Online Comment

Application H09-0874-19
Location WILLOW TREE FARM SPALDING ROAD HOLBEACH PE12 7HP
Proposal Proposed extension to form annexe

Name Sue Armour
Address Council Offices Spalding PE11 2XE

Drawing
FLOOR PLAN - PROPOSED
ELEVATION - PROPOSED
SITE PLAN - PROPOSED

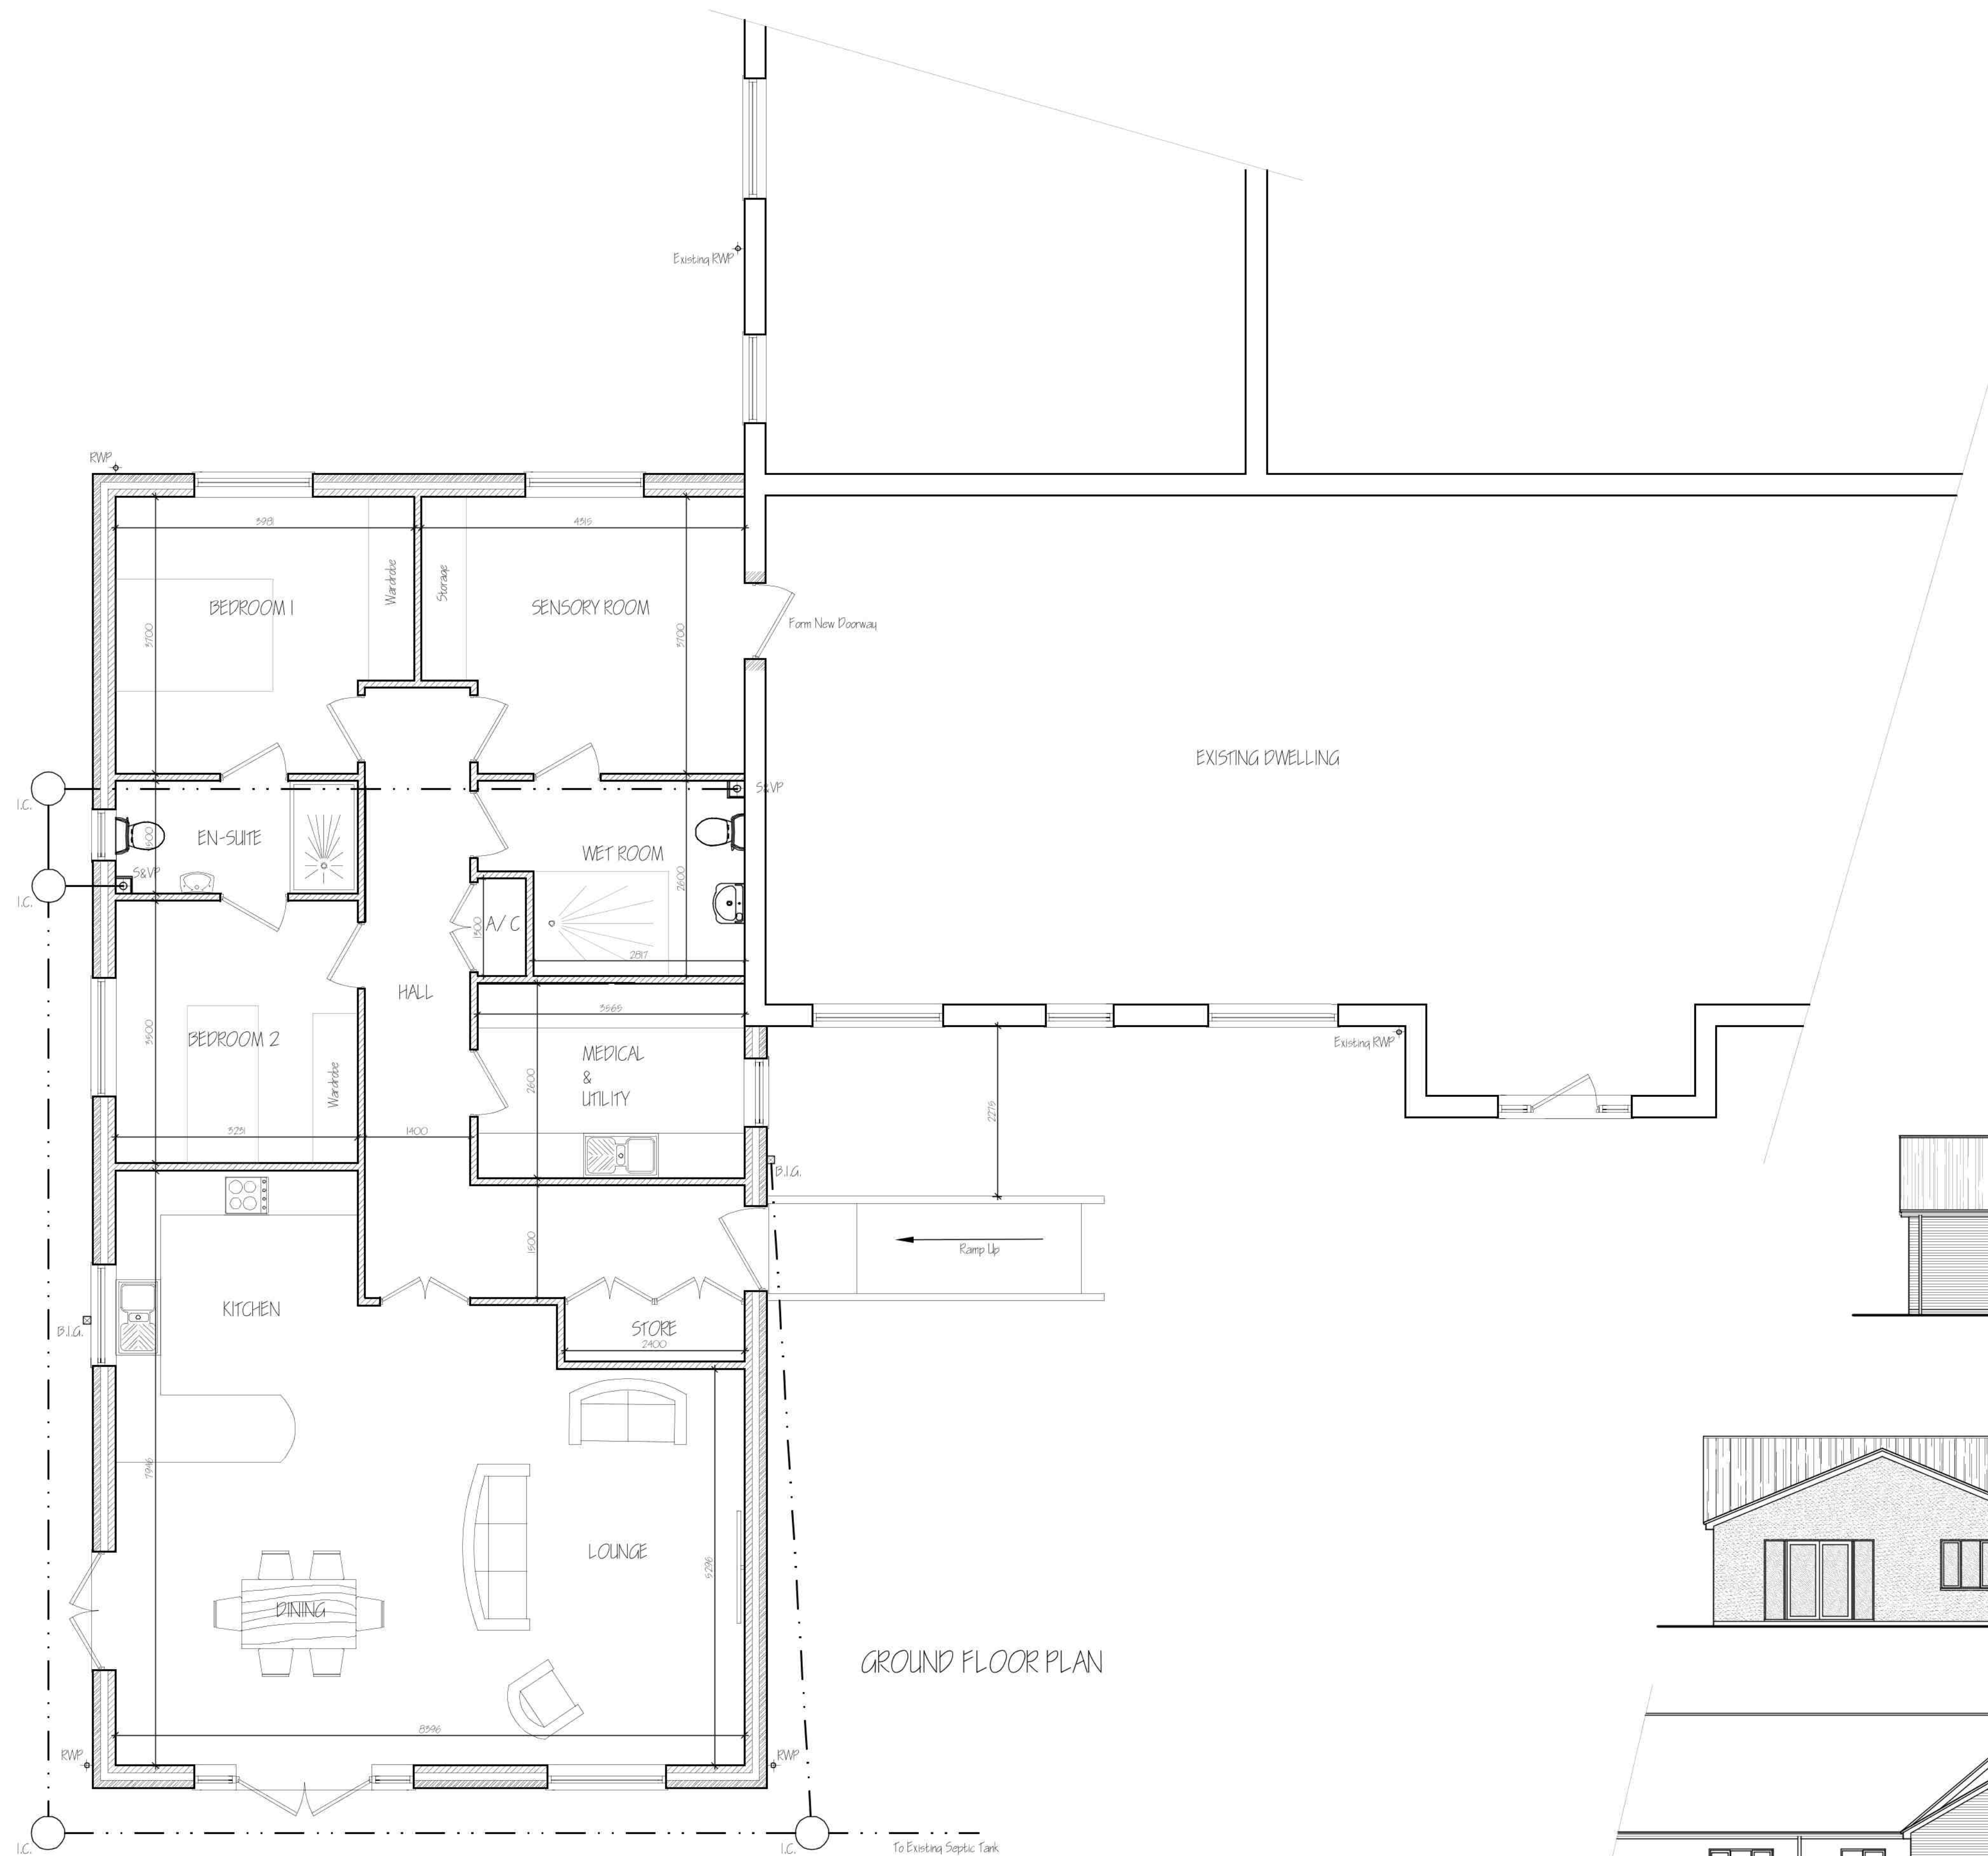
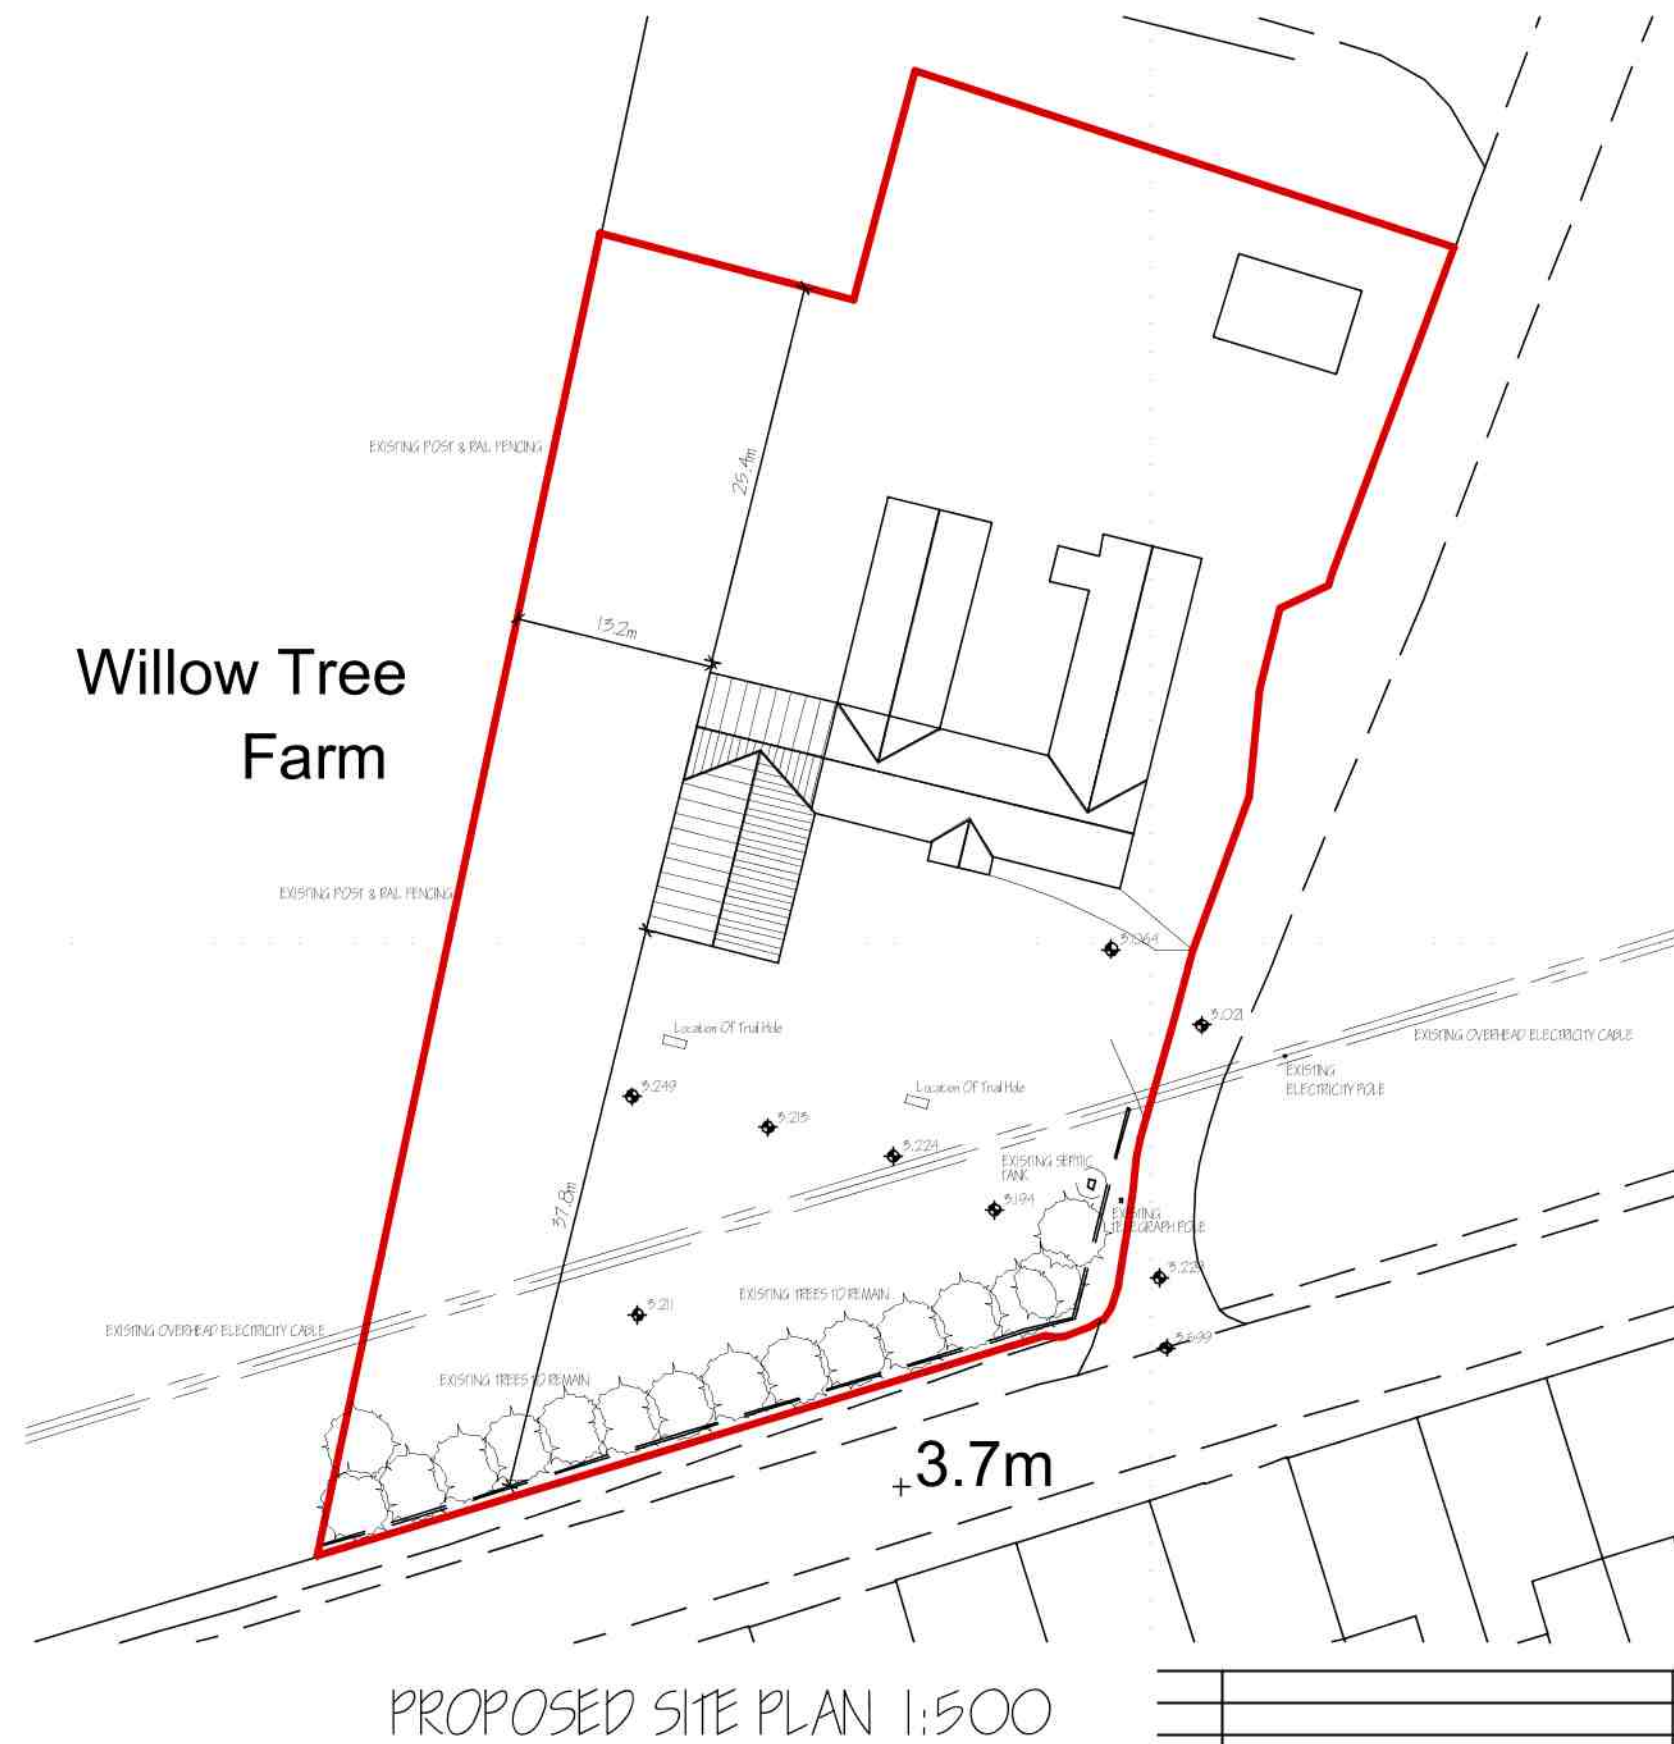
Our records indicate that the application area forms part of a landfill. Further information is required prior to determination in order to ensure a safe development. This would normally take the form of a desk study, and potentially some site investigation to determine the presence/ absence of fill material below the development.

The area indicated to be landfill is significantly larger than the application area, and it may be that the applicant has information already which would assist. There are also other landfills within 250m.
